NORTHAW & CUFFLEY PARISH COUNCIL

27th July 2009

The Planning Committee of the Northaw and Cuffley Parish have reached a decision and there were **no objections** to the following: -

Drawing Title
 Proposed Elevations

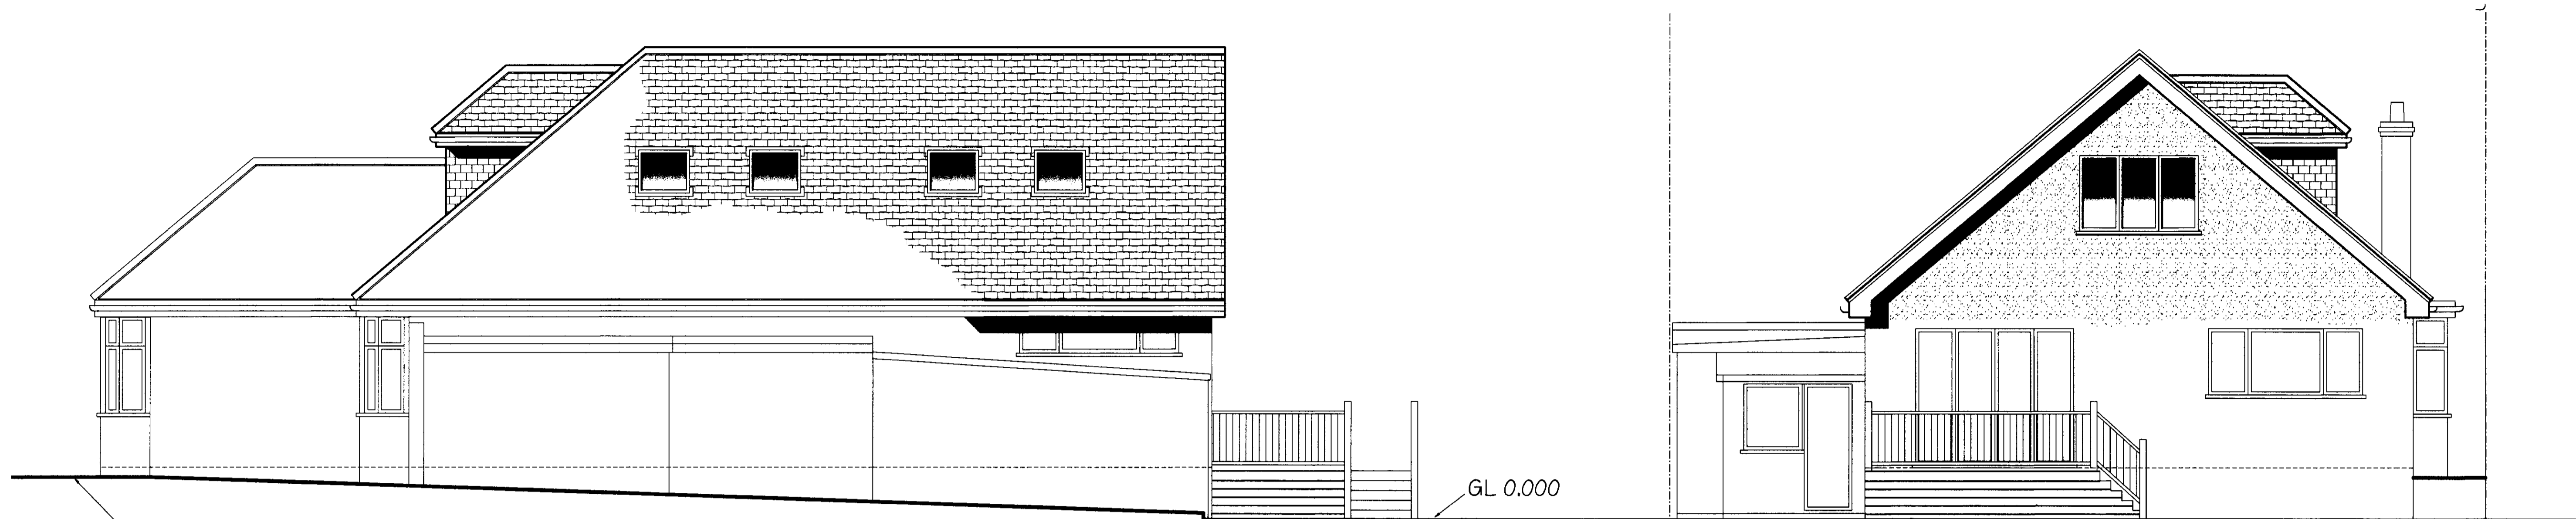
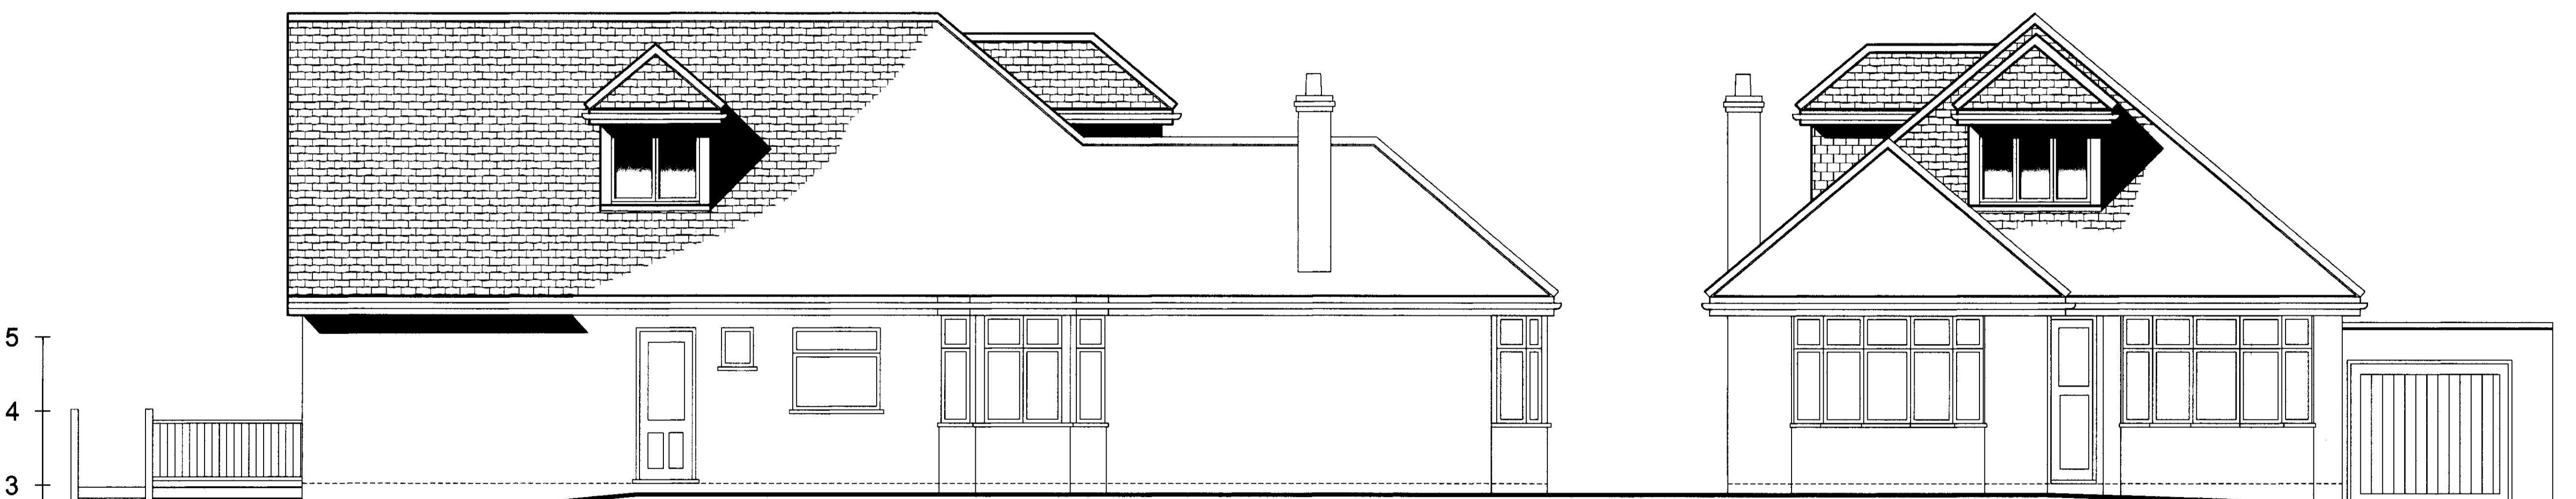
DM S6/09/1438/FP 46 Plough Hill, Cuffley
Installation of front dormer window and an extension to roof to include a side dormer and four roof lights
No objection but have concerns regarding overlooking of neighbours of side dormer
